Our ref: 270 Pacific Hwy Crows Nest BTR (SSD-79658964)

19 September 2025

Subject: Request for Additional Information

DRAWING
 GENERAL ARRANGEMENT PLANS
LEVEL 02 - RESIDENTIAL AMENITIES

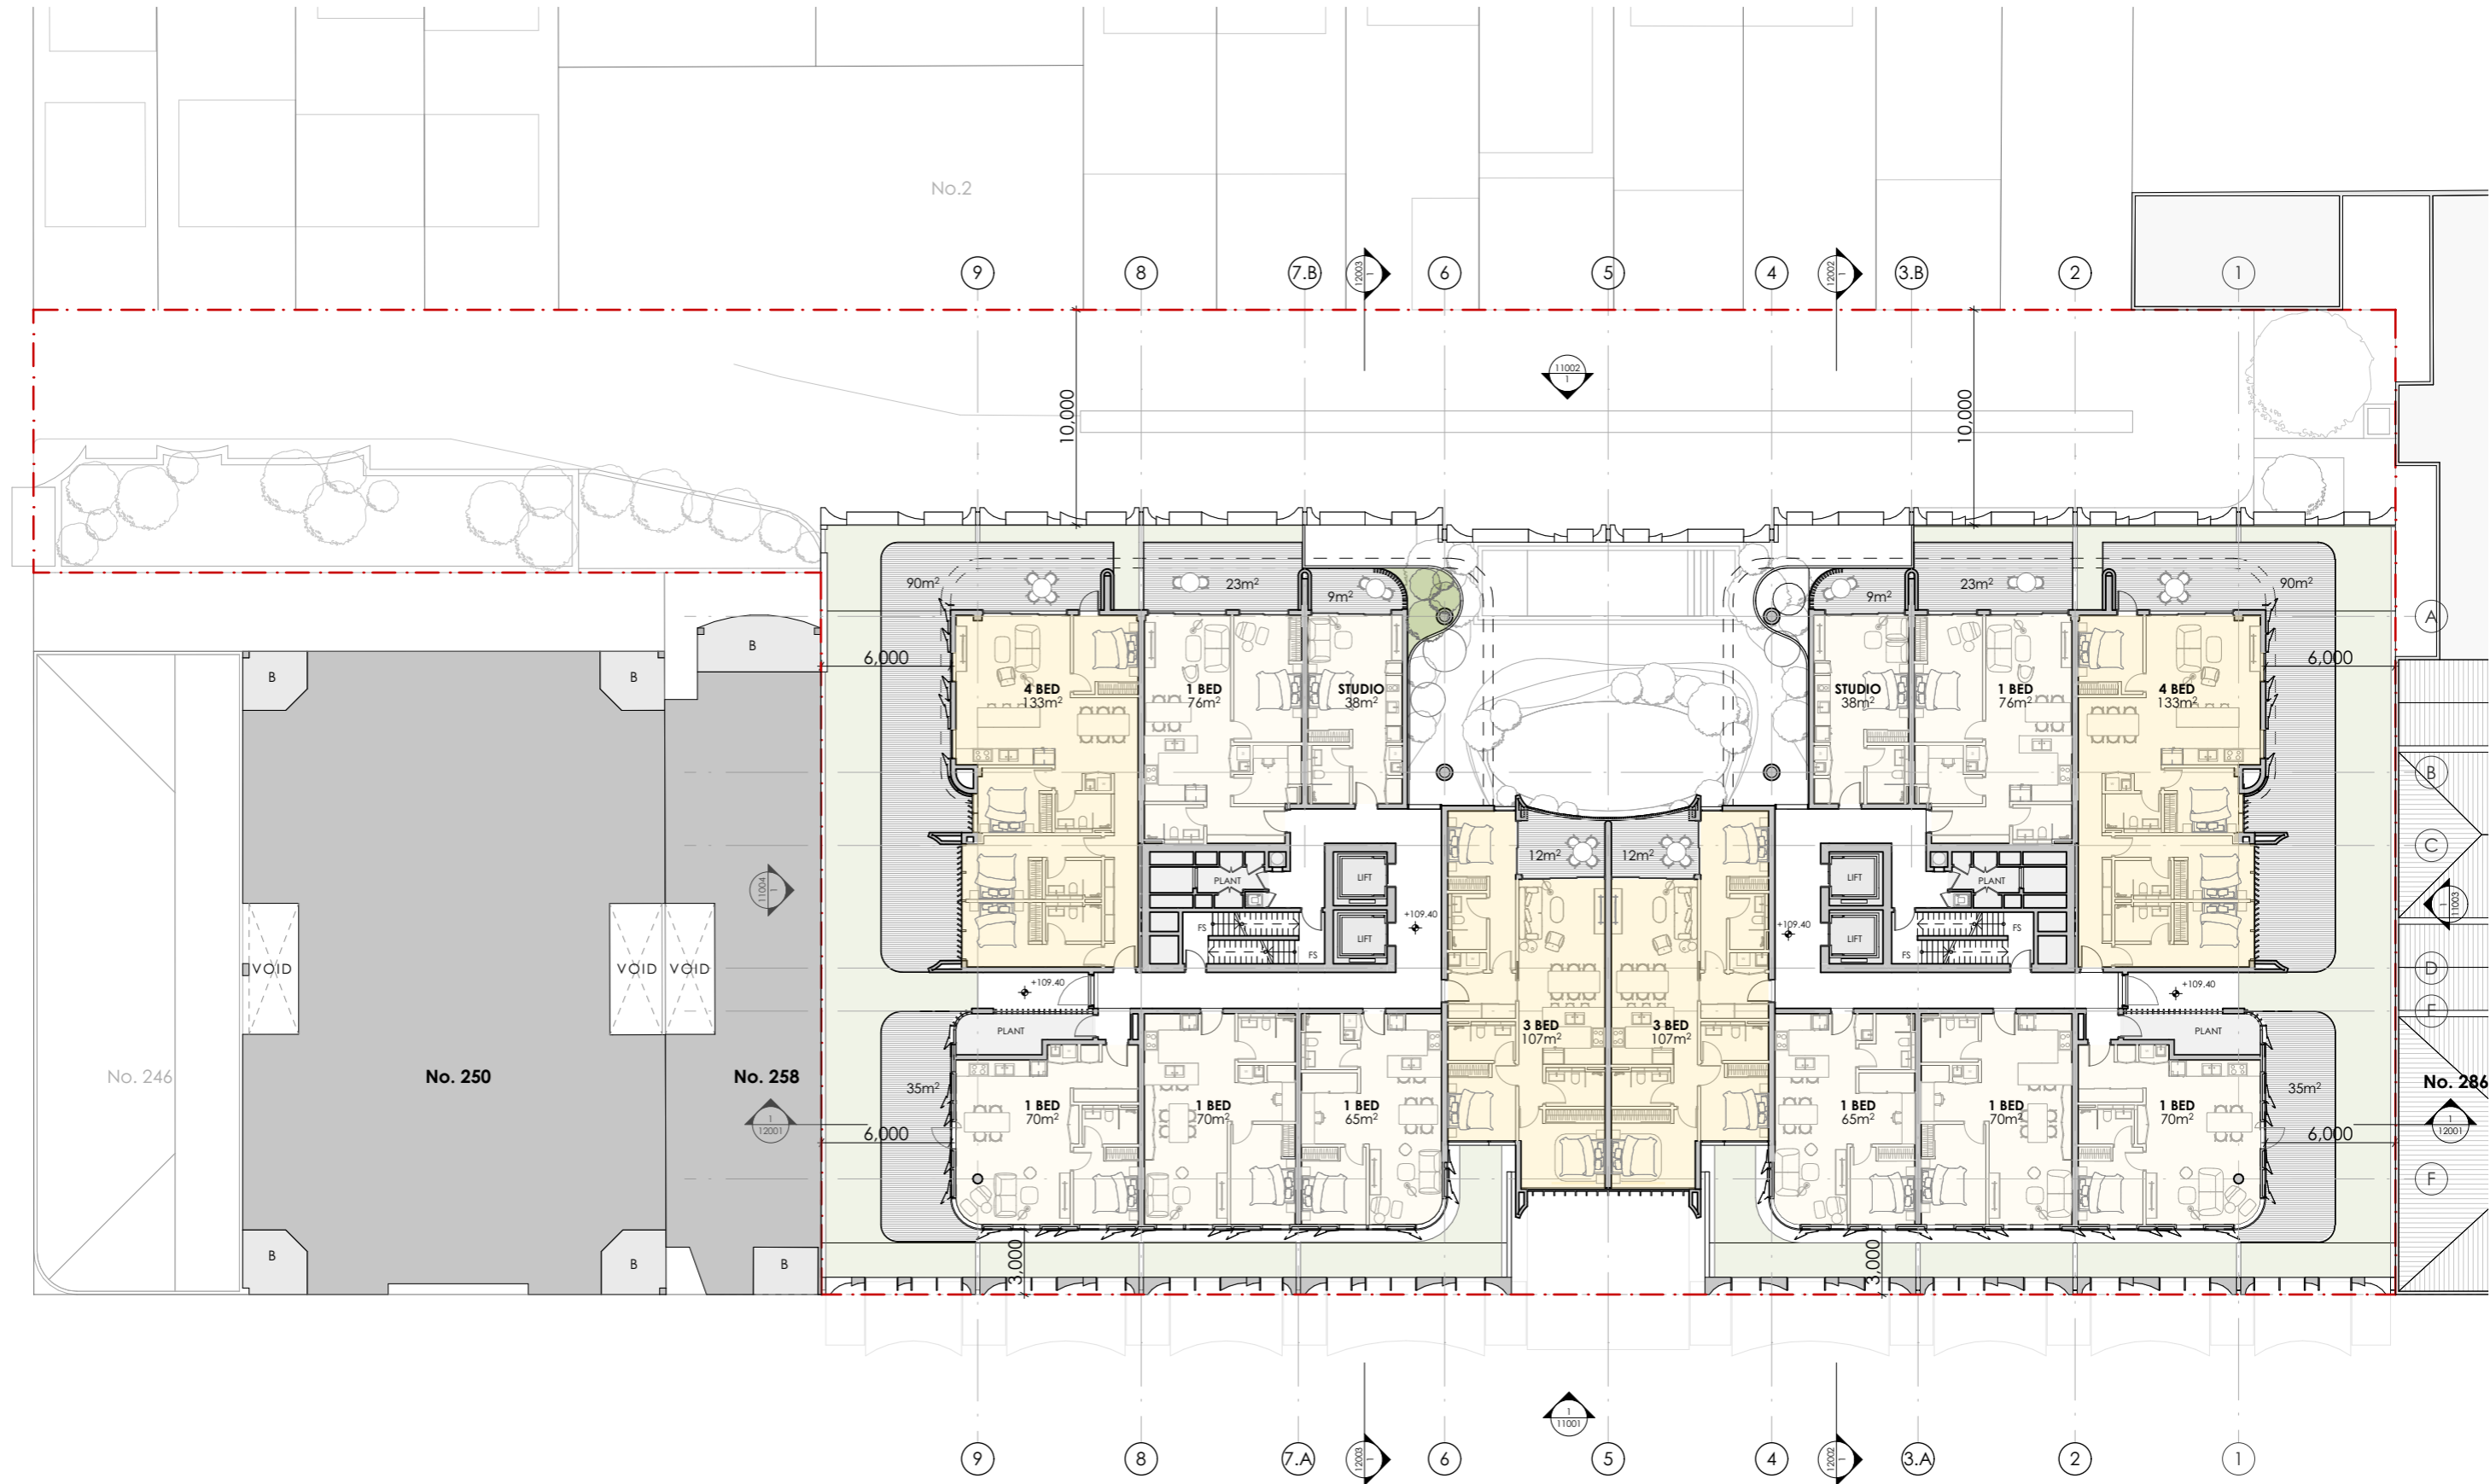
The level 2, 12 and 14 communal terrace/balcony areas are surrounded by barriers that exceed 1.4 m in height. The Department has reviewed the articles from Mills Oakley provided by the Applicant (dated 31 July 2020 and 14 July 2021) on calculating gross floor area (for FSR purposes) in NSW. It is considered that these scenarios do not directly apply to this development and do not satisfactorily justify that these areas do not constitute gross floor area.

The Department maintains its position that these areas meet the definition of gross floor area as described in *North Sydney Local Environmental Plan 2013* and are to be included in the GFA calculations. It is noted that this will result in the development exceeding the maximum 5.6:1 FSR and a clause 4.6 variation request will be required to support the exceedance of floor space.

SCALE	DRAWN BY	APPROVED BY	DRAWING ELEVATION
1:300 @A3			ELEVATION - NORTH
30mm ON ORIGINAL		PRINT DATE 23/10/2025	PROJECT NUMBER 22501
		DRAWING NUMBER DA-11003	ISSUE B

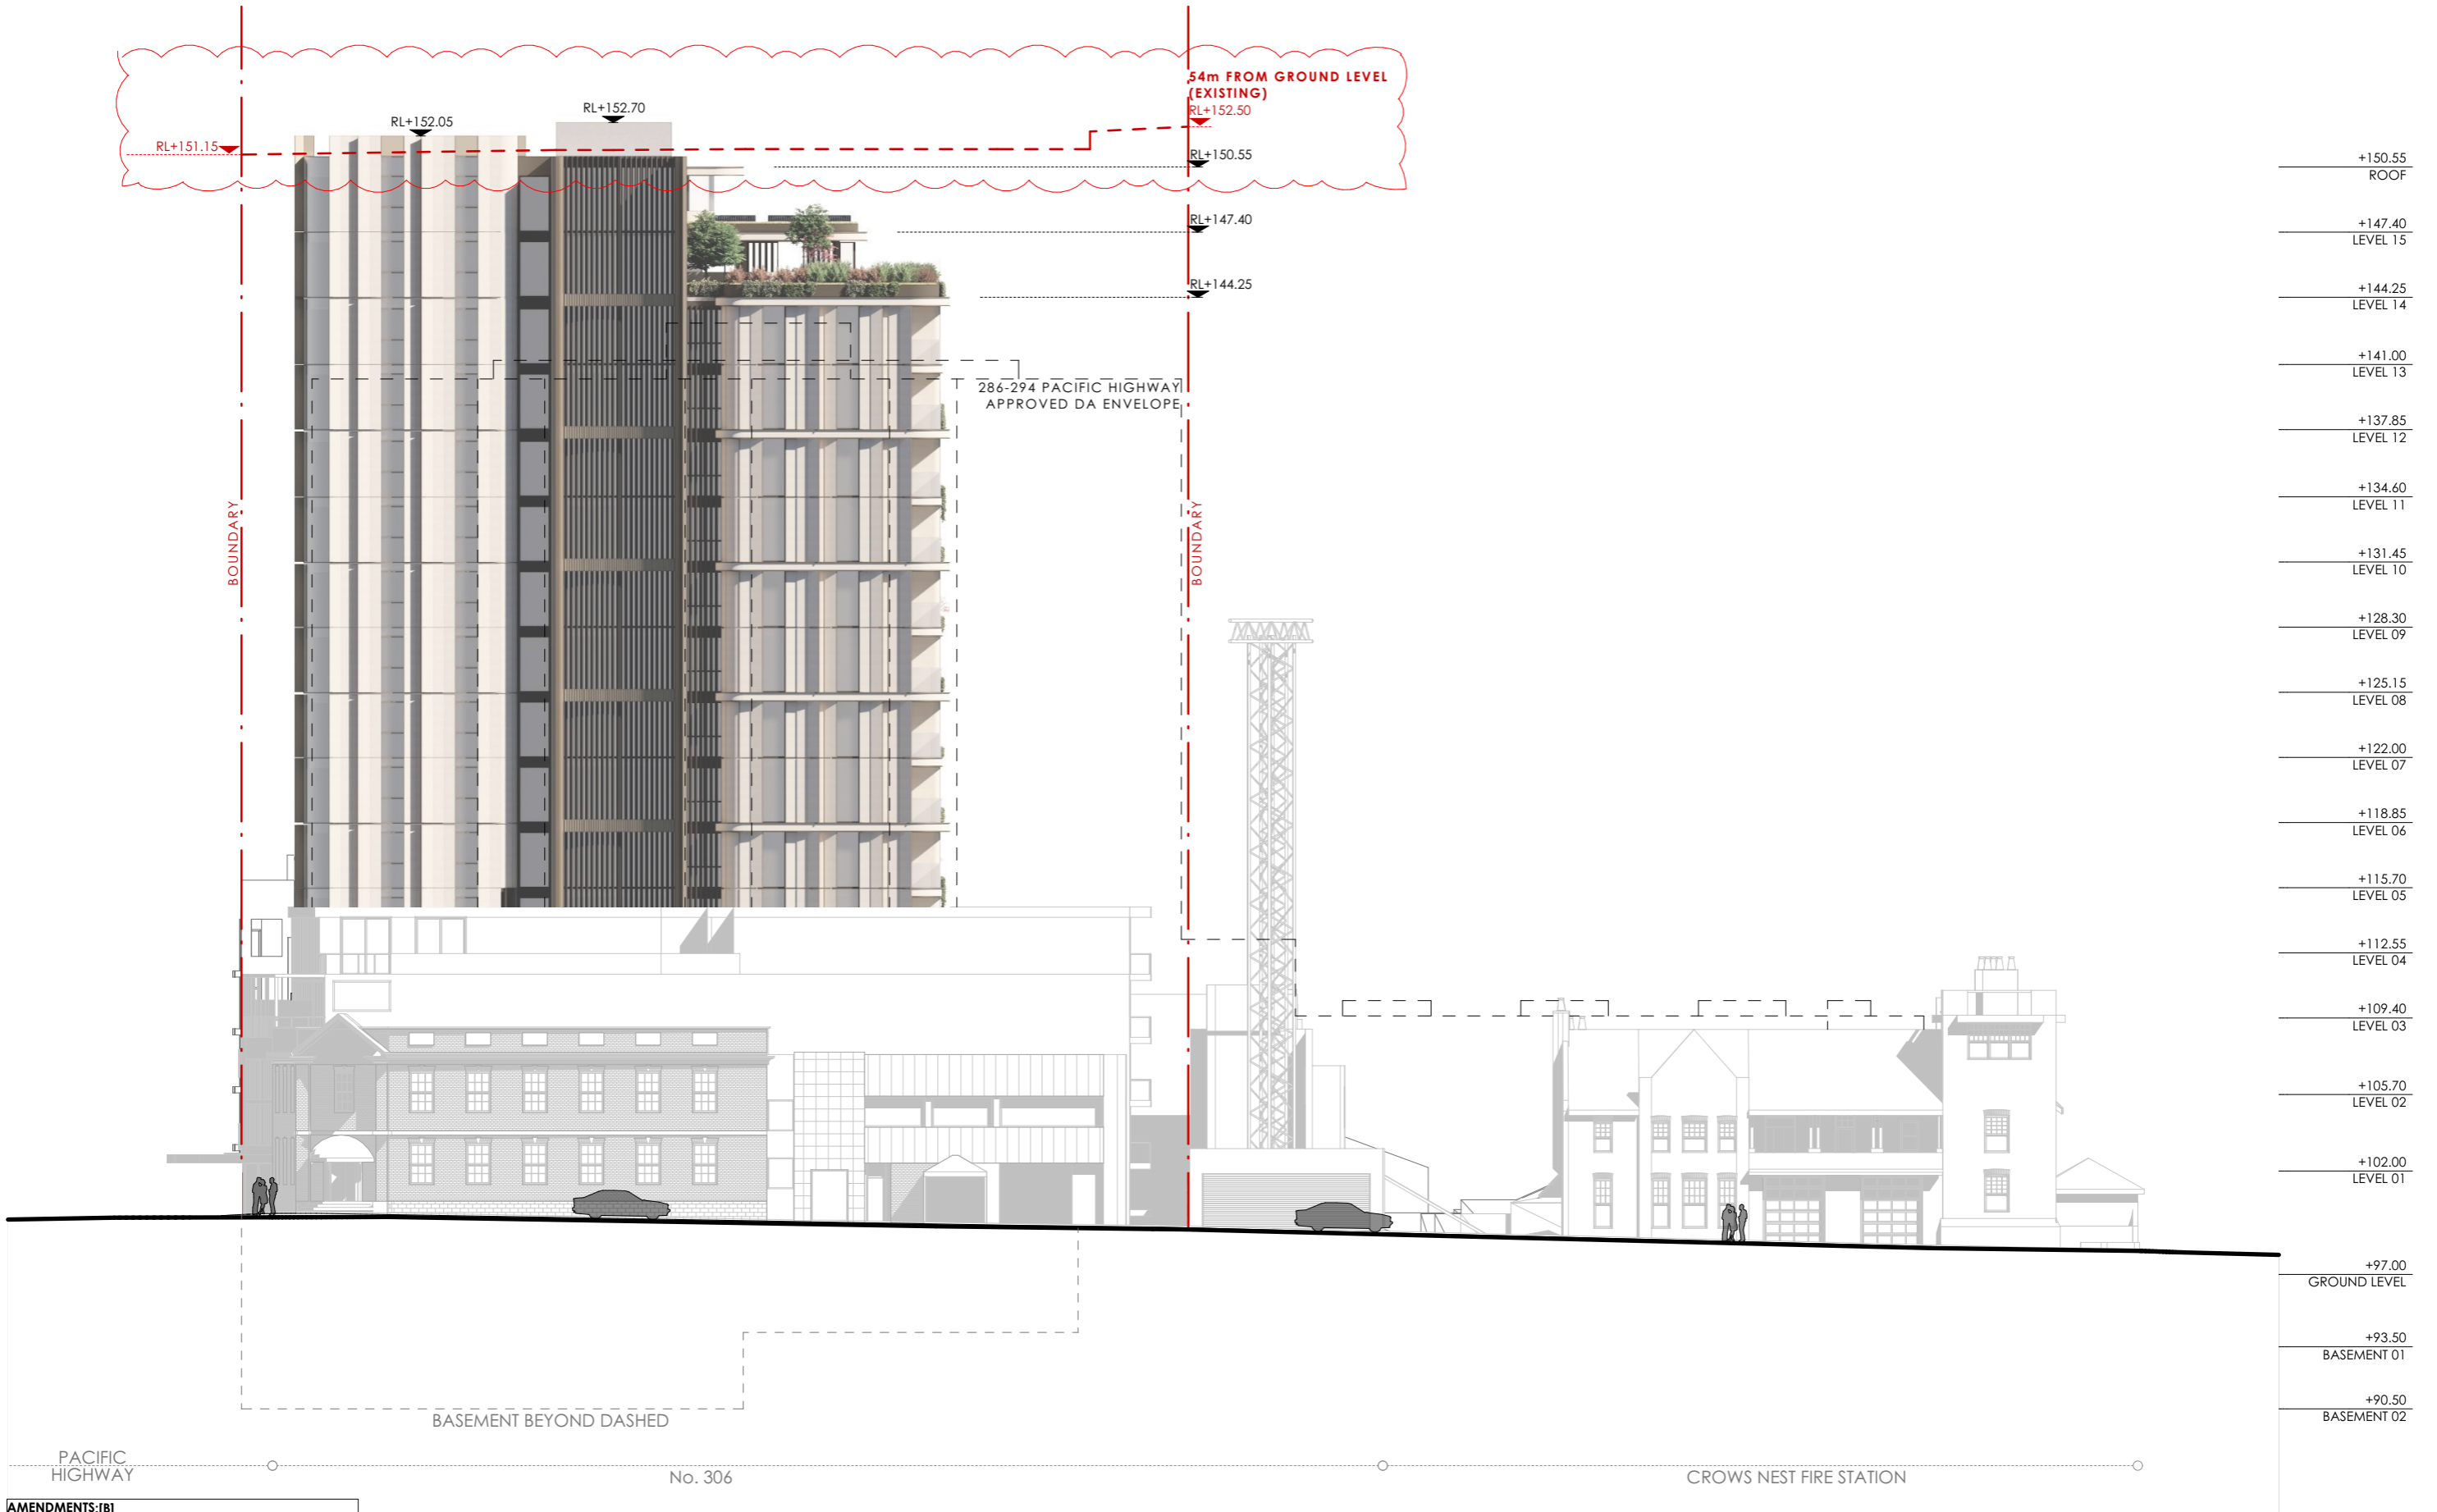
The clause 4.6 variation request for height has assessed the maximum building height using the 'Merman' method. The Department does not consider that the decision in *Merman Investments Pty Ltd v Woollahra Municipal Council* [2021] NSWLEC 1582 (Merman) sets a precedent for the meaning of 'existing ground level' and the calculation of maximum building height that the Department is required to adhere to.

The Department considers that the more appropriate way to extrapolate 'existing ground level' in this instance is to use the 'Bettar' method (*Bettar v Council of the City of Sydney* [2014] NSWLEC 1070). The Department considers that the determination of the existing ground level should relate to the overall topography of the site. This can include considering the footpath level and the rear laneway level for this site. This approach would result in a more appropriate height plane for the site consistent with the intention of the height control described in the *North Sydney Local Environmental Plan 2013*.

This method of determining ground level (existing) has been affirmed in several other recent cases. It is requested that the clause 4.6 variation request is updated to reflect this application of determining ground level (existing).

The Department considers that the current amenity outcome achieved for these units can be improved. The Department recommends that the design is amended to include operable windows on all units, at a minimum, to achieve an acceptable level of amenity for all units, being a minimum of 60% of units receiving natural cross ventilation.
